# CITY OF ALBUQUERQUE

March 18, 2019

**Re: Disco Central LLC**  
**3123 Central Ave NE 87106**  
**Traffic Circulation Layout**  
Engineer's/Architect's Stamp **03-01-2019** (K16D201)

Sheet: Traffic Control Layout

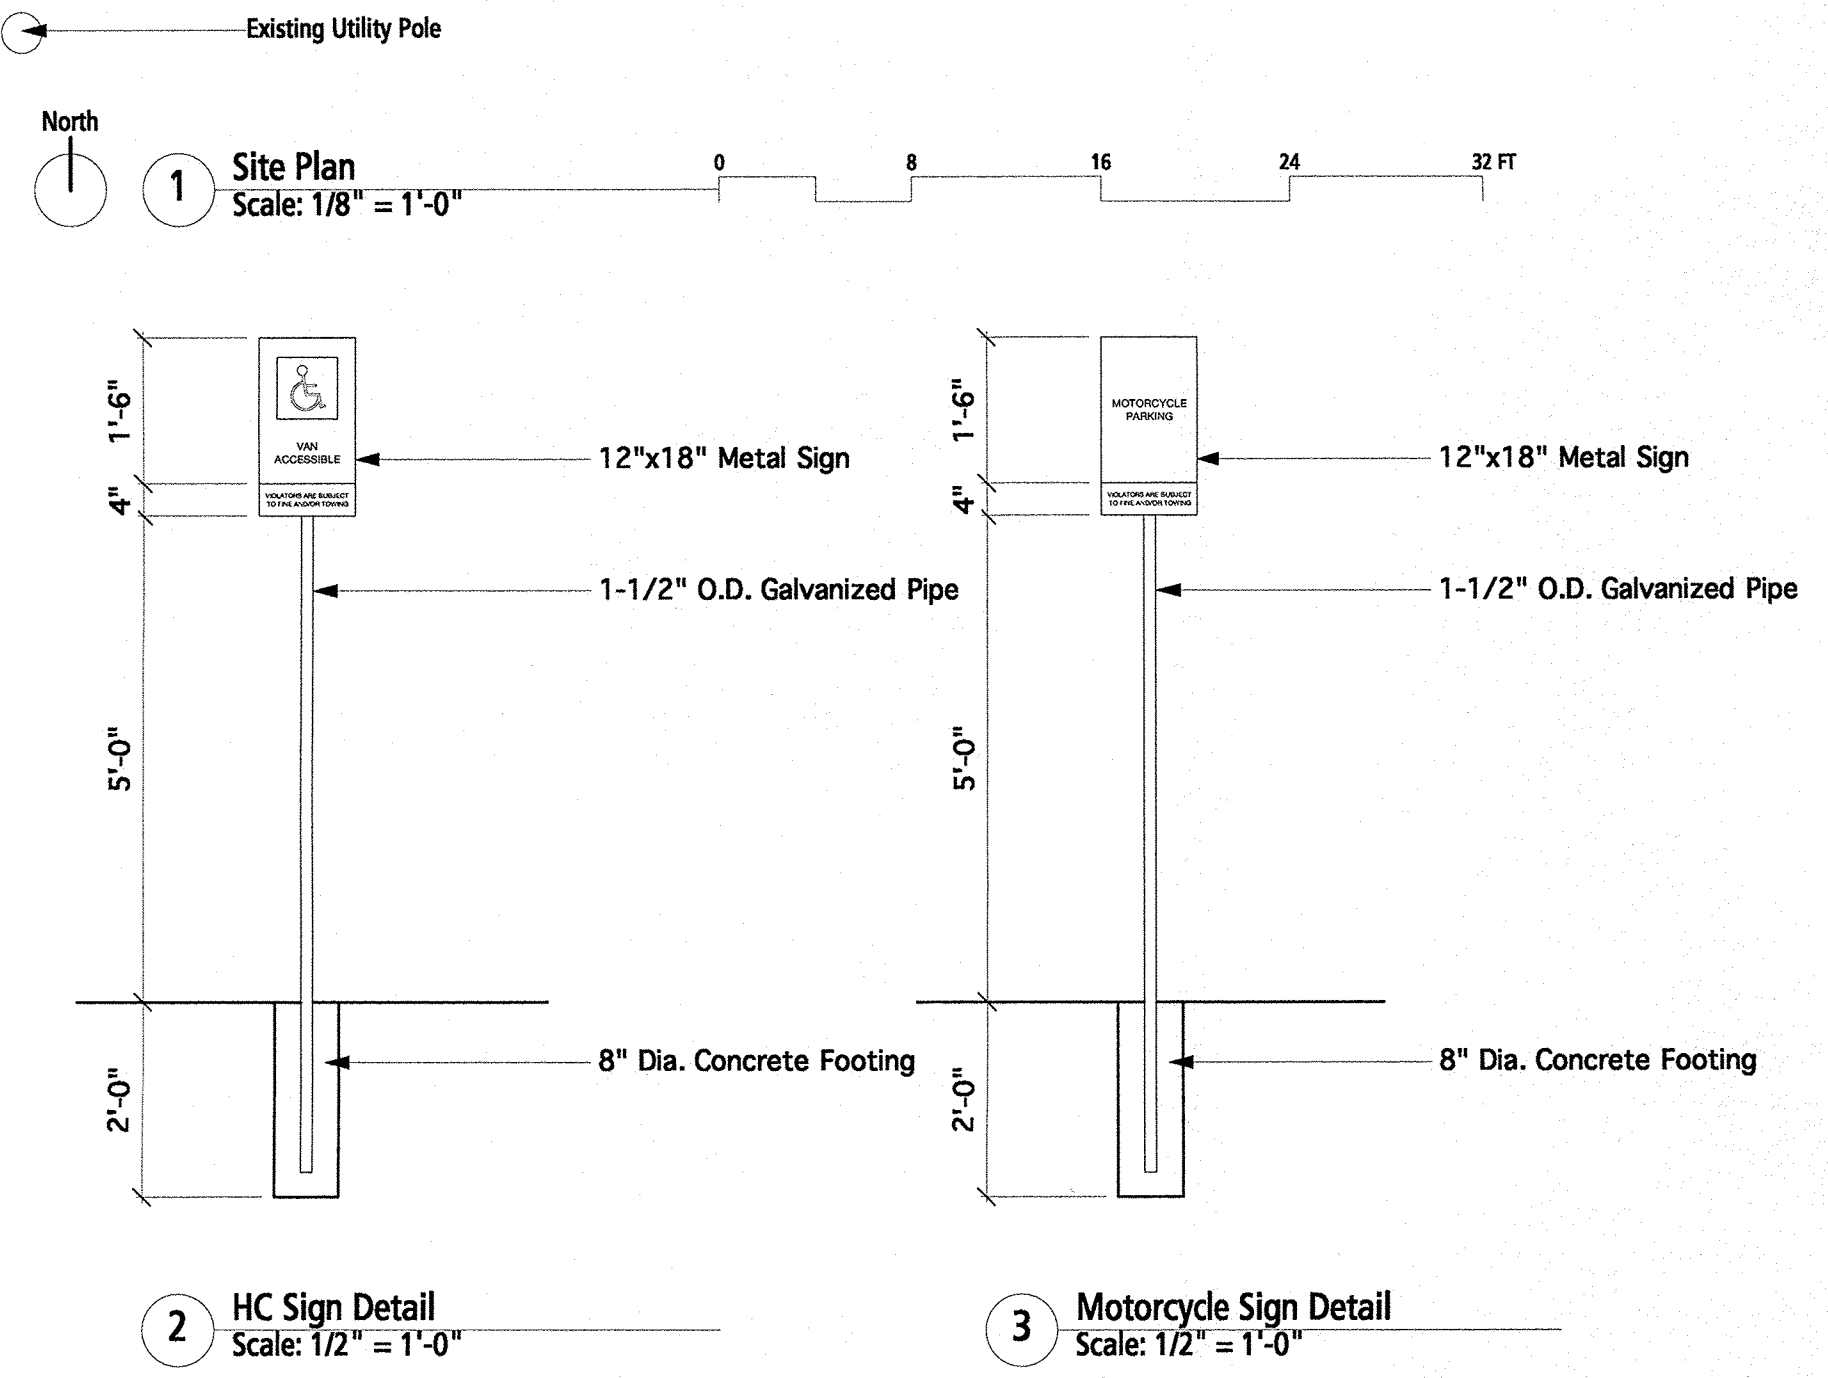
1. The existing drive way located on central is greater than 25'. Please make sure you close the unused portion of the cub cut. That's how the google map shows. If it's different now and it has already been closed, ignore this comment please.

2. Parking spaces cannot cross over lot lines.
3. The access isle cannot crossing over the lot line.
4. The ADA accessible parking sign must have the required language per 66-7-352.4C NMSA 1978 **"Violators Are Subject to a Fine and/or Towing."** Please call out detail and location of HC signs.

5. The ADA access aisles shall have the words **"NO PARKING"** in capital letters, each of which shall be at least one foot high and at least two inches wide, placed at the rear of the parking space so as to be close to where an adjacent vehicle's rear tire would be placed. (66-1-4.1.B NMSA 1978)

6. ADA curb ramps must be updated to current standards and have truncated domes installed.
7. Motorcycle parking spaces shall be designated by its own conspicuously posted upright sign, either free-standing or wall mounted per the zoning code.

8. Per the zoning code, a 6 ft. wide ADA accessible pedestrian pathway is required from the public sidewalk to the building entrances. Please clearly show this pathway and provide details.

9. Per DPM, a 6 ft. wide ADA accessible pedestrian pathway is required from the HC parking stall access aisles to the building entrances. Please clearly show this pathway and provide details.

10. ADA accessible pedestrian pathway should not be placed behind parking space or adjacent to a vehicular way. Vehicle and pedestrian/wheel chair conflicts should be avoided as much as possible.
11. Service vehicle and/or refuse vehicle maneuvering must be contained on-site; provide a copy of refuse approval.
